Your Ref: OWPC23470
Our Ref: A/55/19/PL 30-04-2019
Please ask for:
Mrs A Gardner

Construction of 1 No. new two storey house (resubmission following A/31/19/PL). This application is a Departure from the Development Plan & affects a Public Right of Way.

Land between Ashurst and Badgers Ham Manor Way Angmering

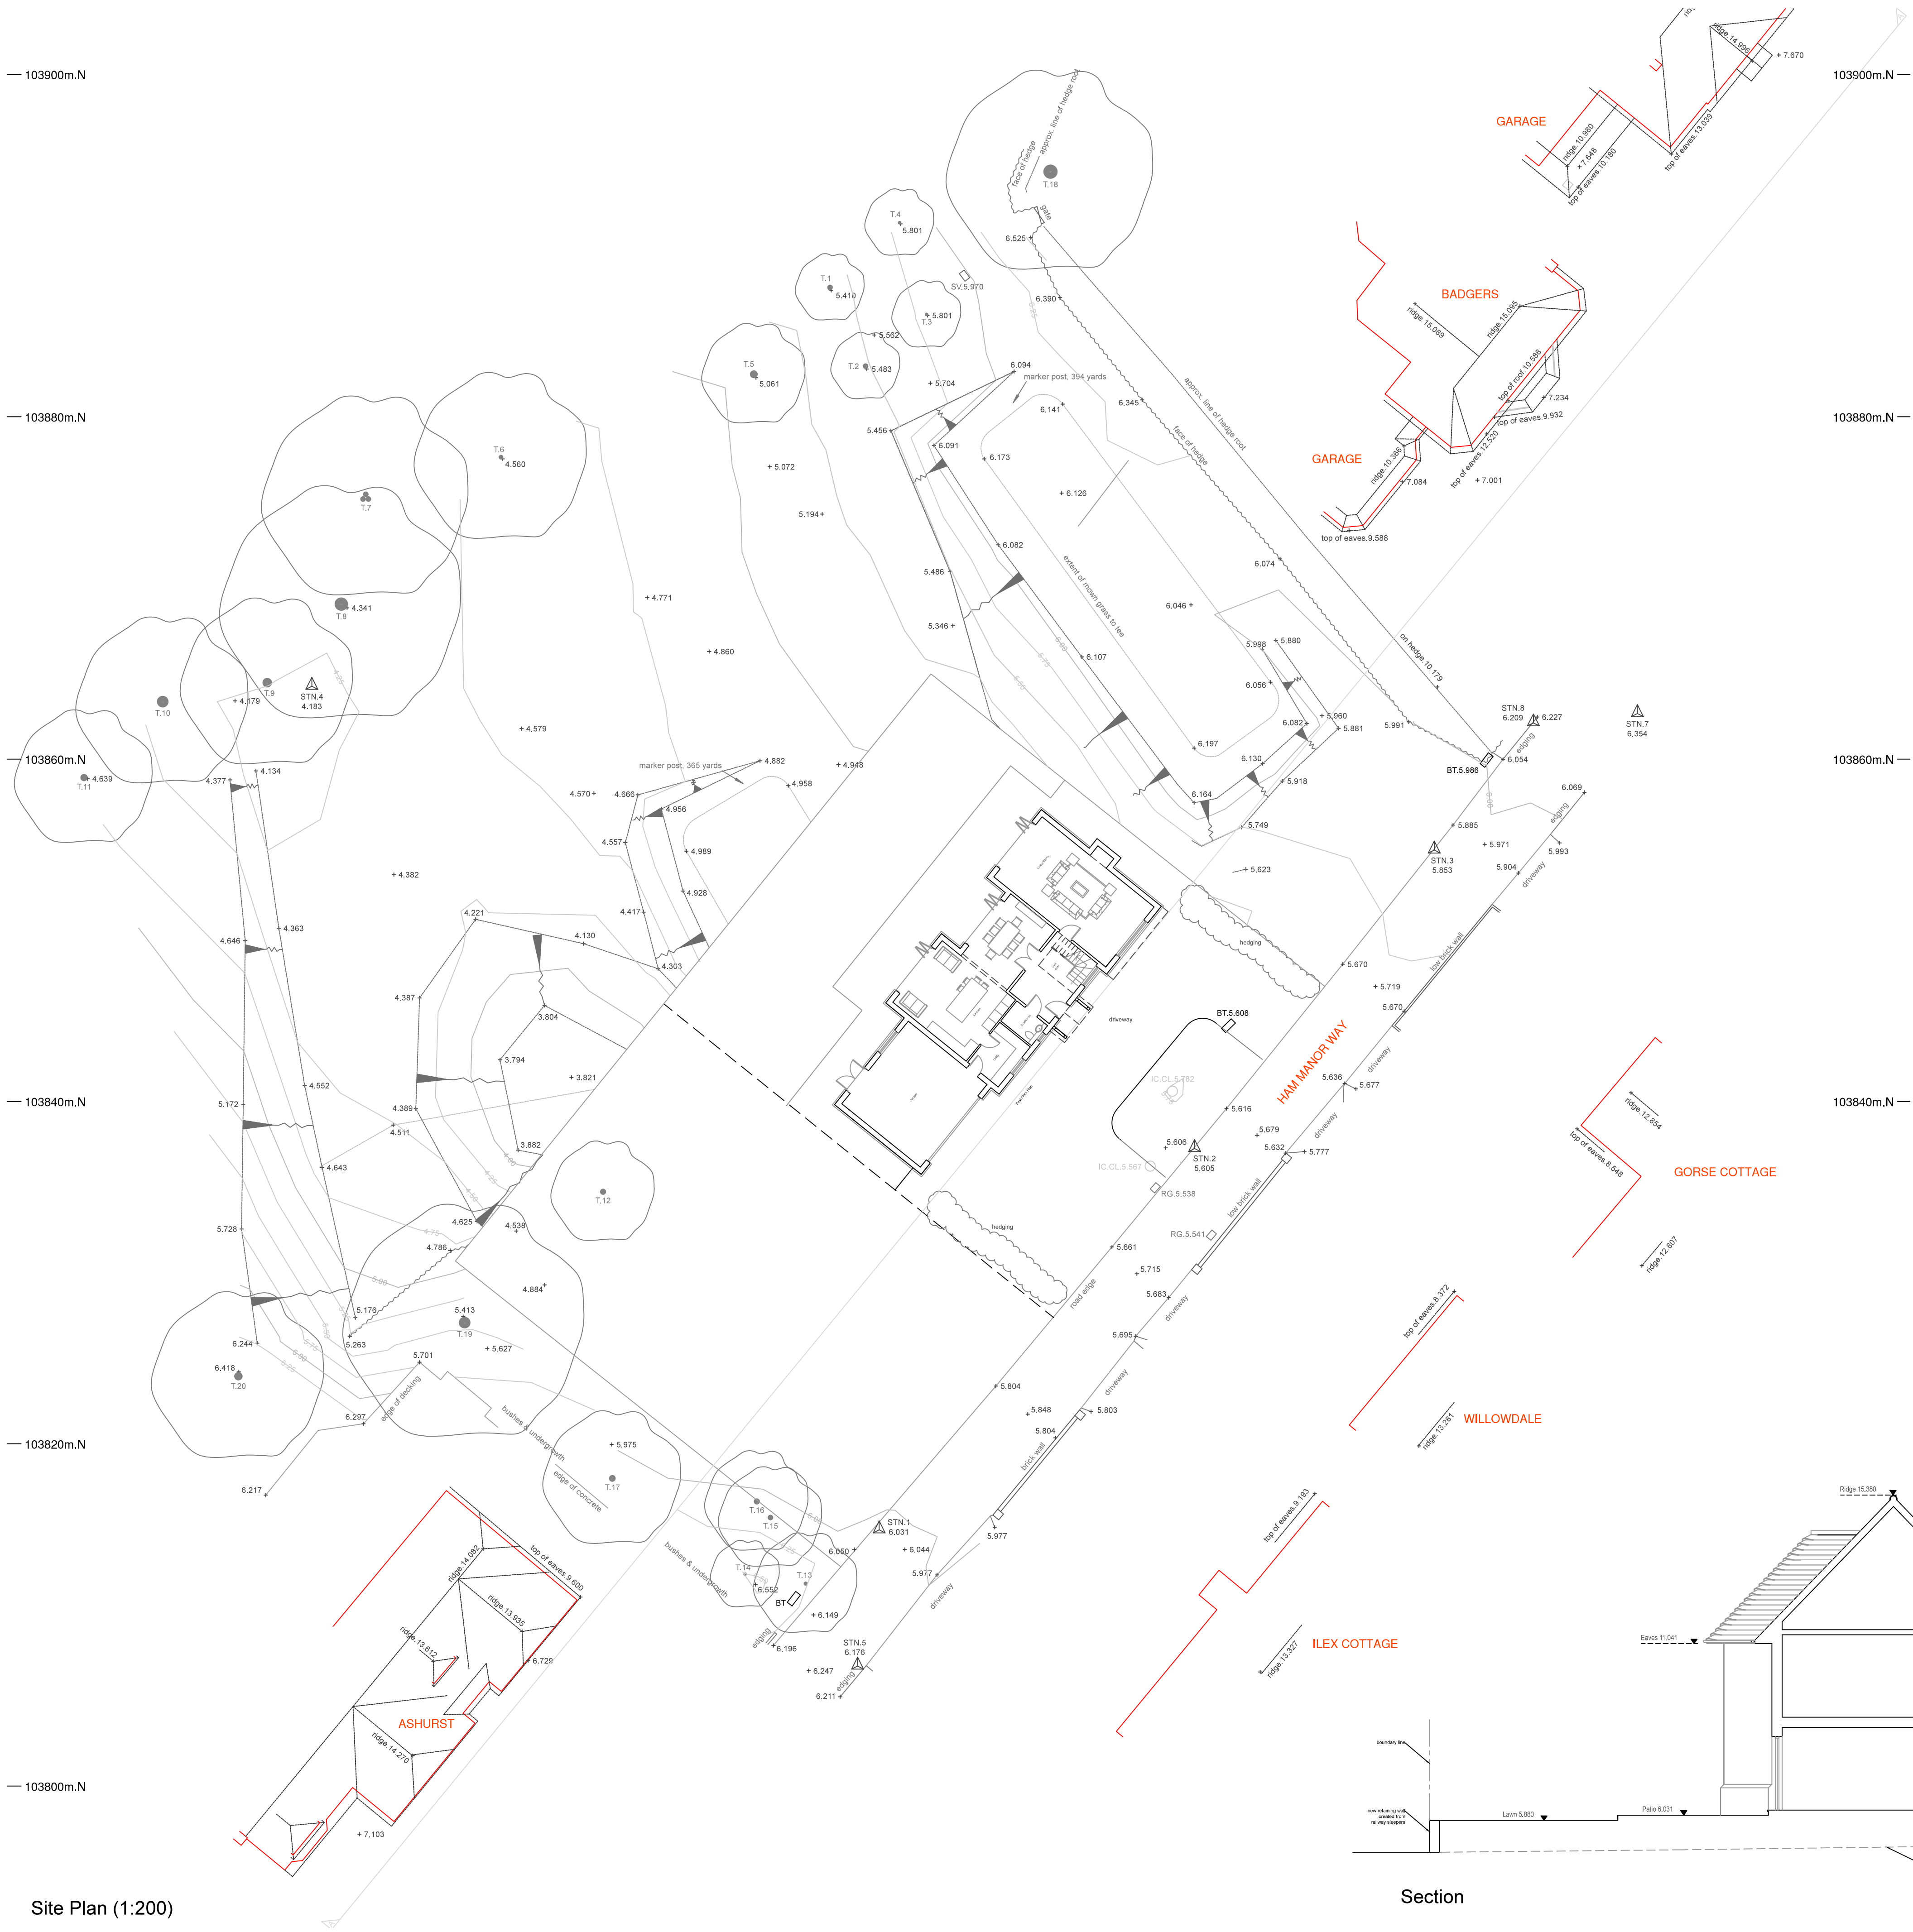
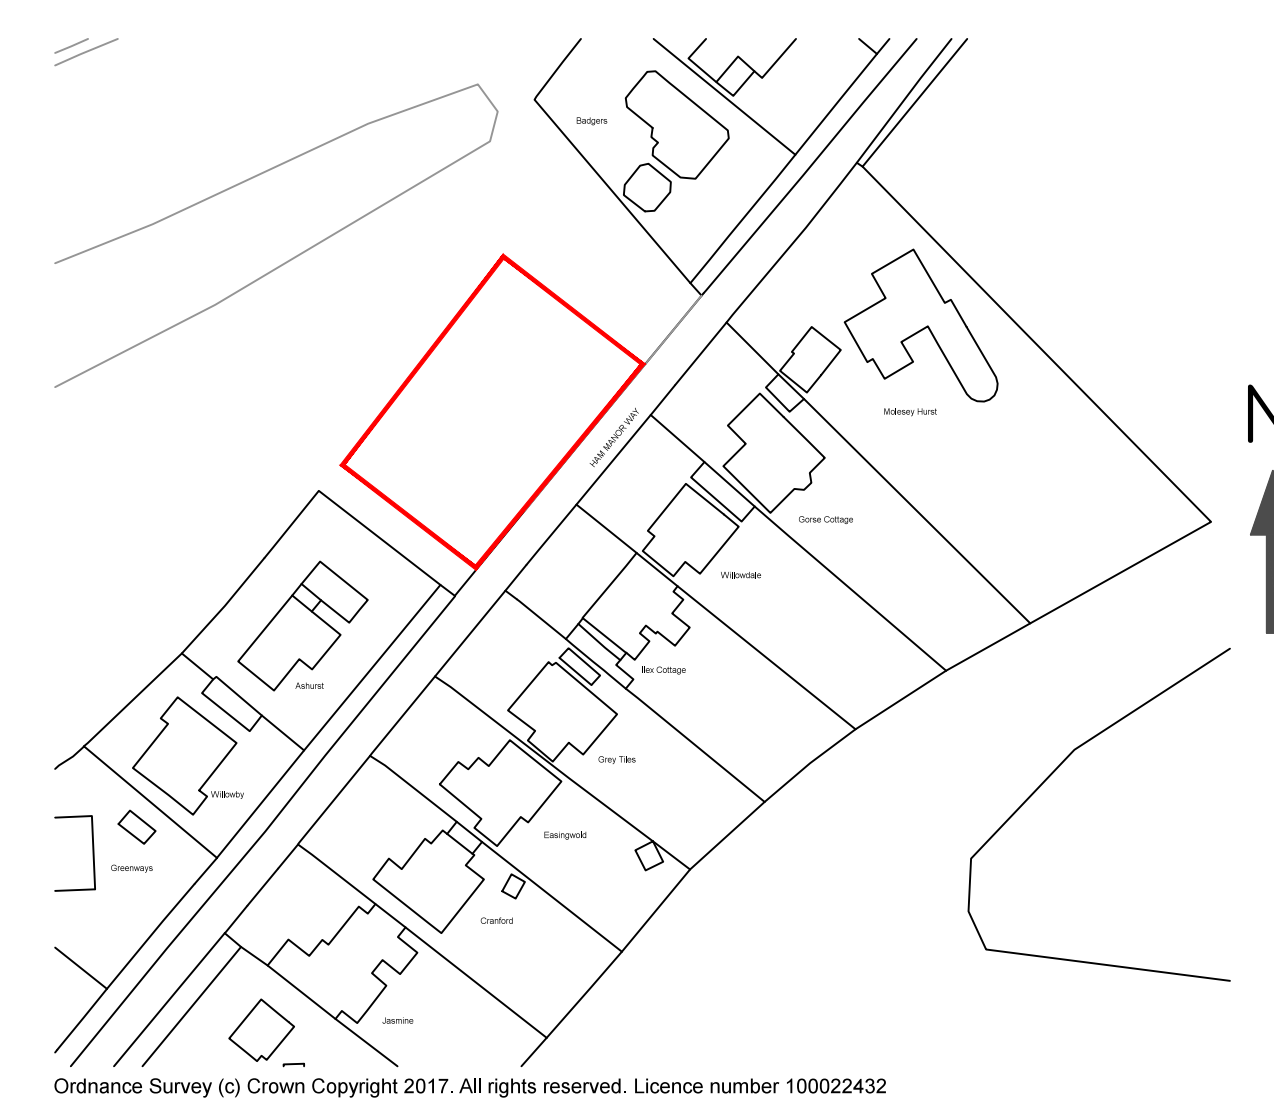
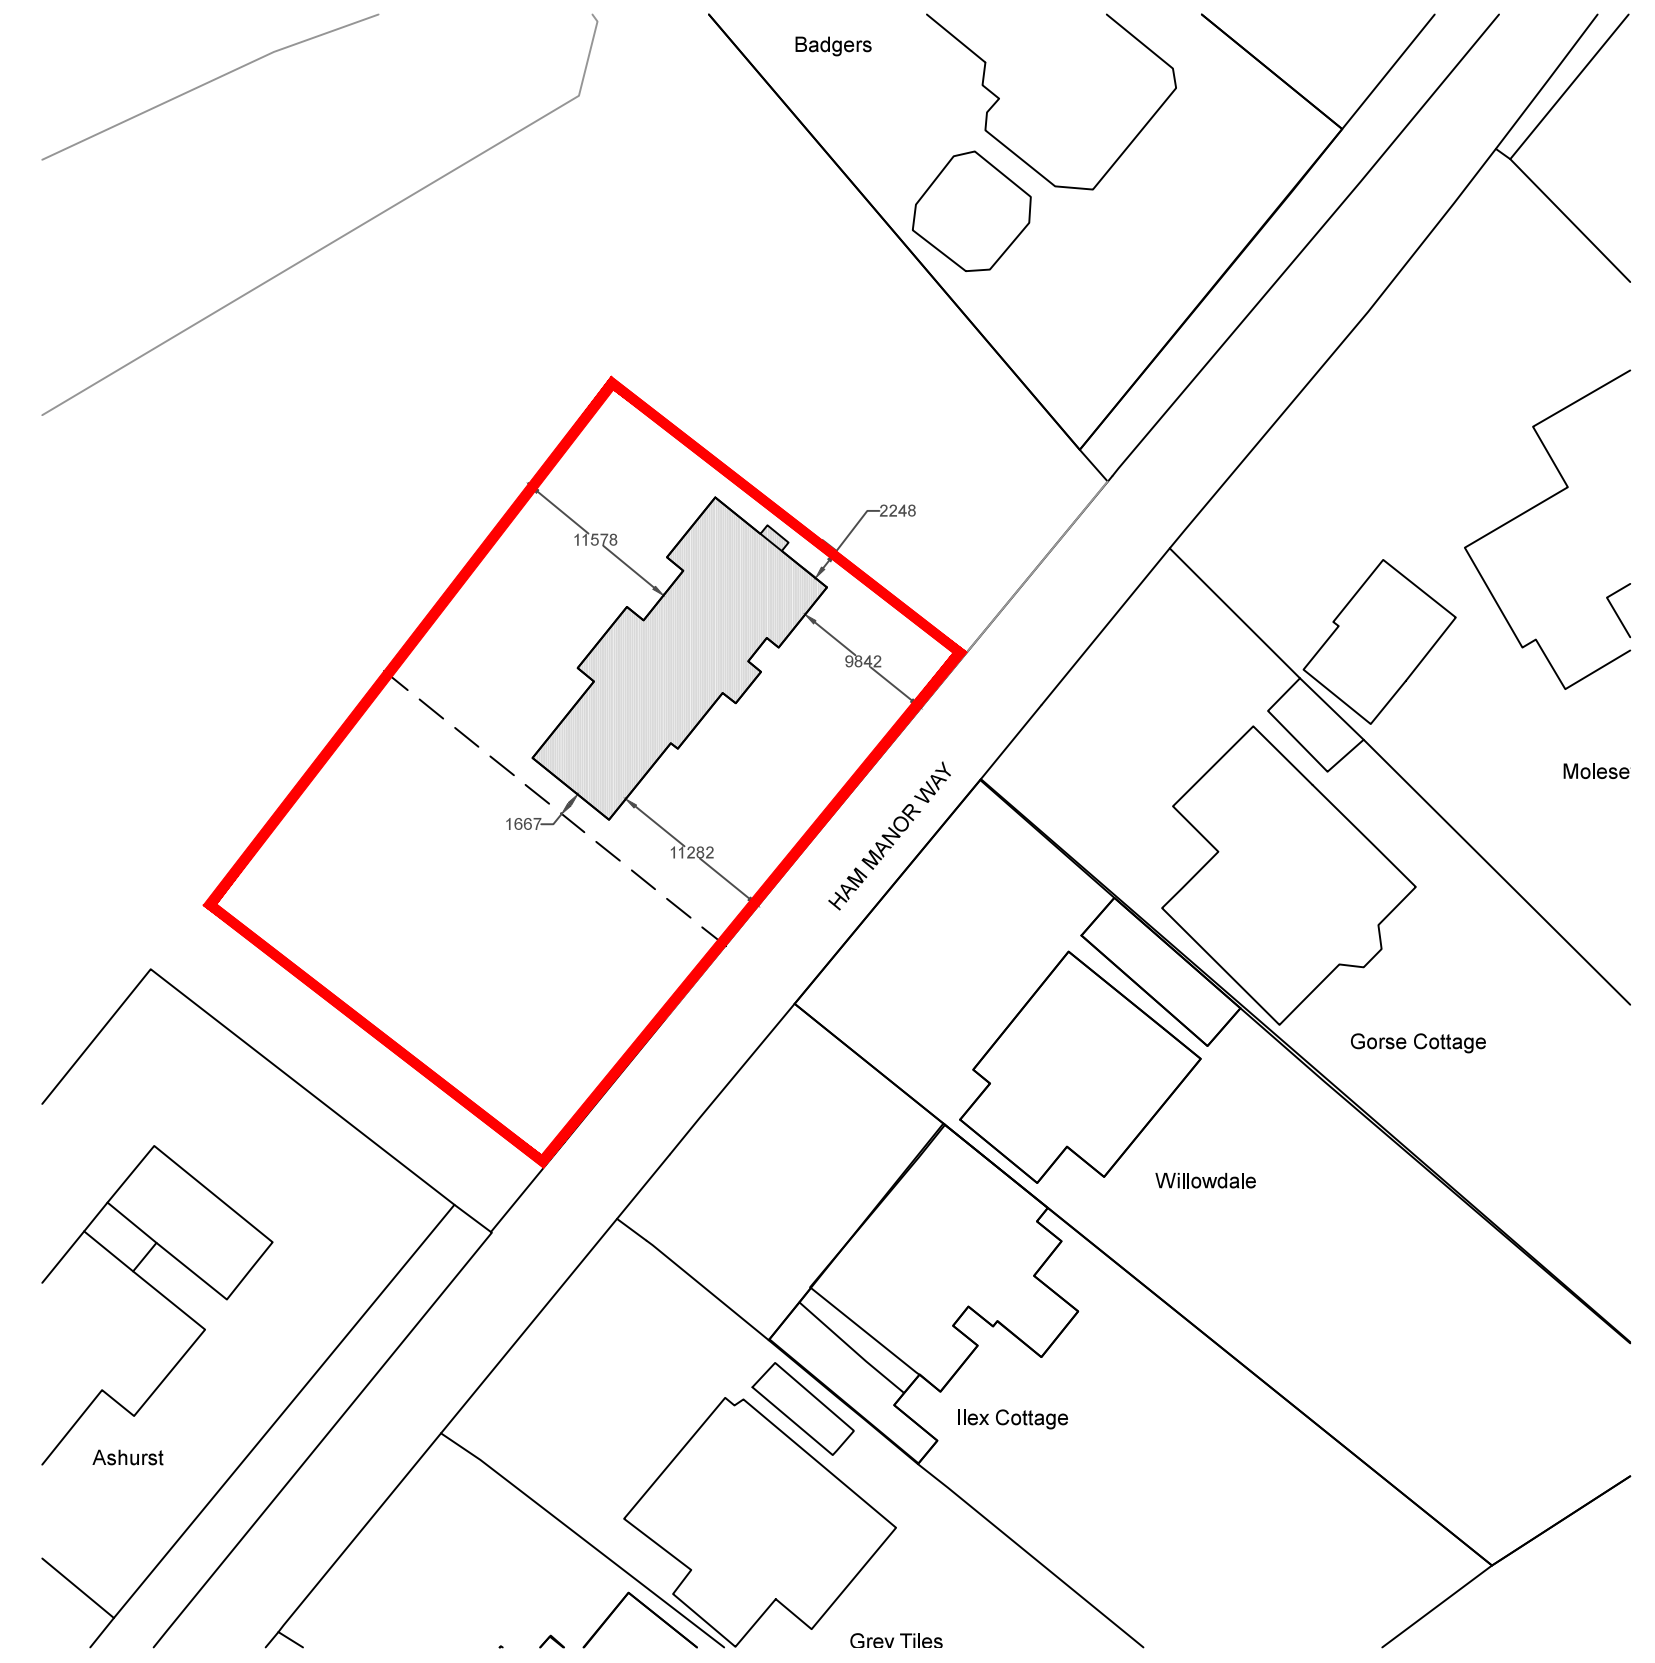
The most recent application ADC application A/31/19/PL was rejected on 29th April 2019 on the grounds that the position of the dwelling within the golf course, which is designated as a Local Green Space in the ANDP, would represent an unacceptable incursion into the area and would constitute a prominent form of development which would adversely affect the character and appearance of the area in conflict with policies CSP1, DDM1 and OSR DM1 of the Arun Local Plan
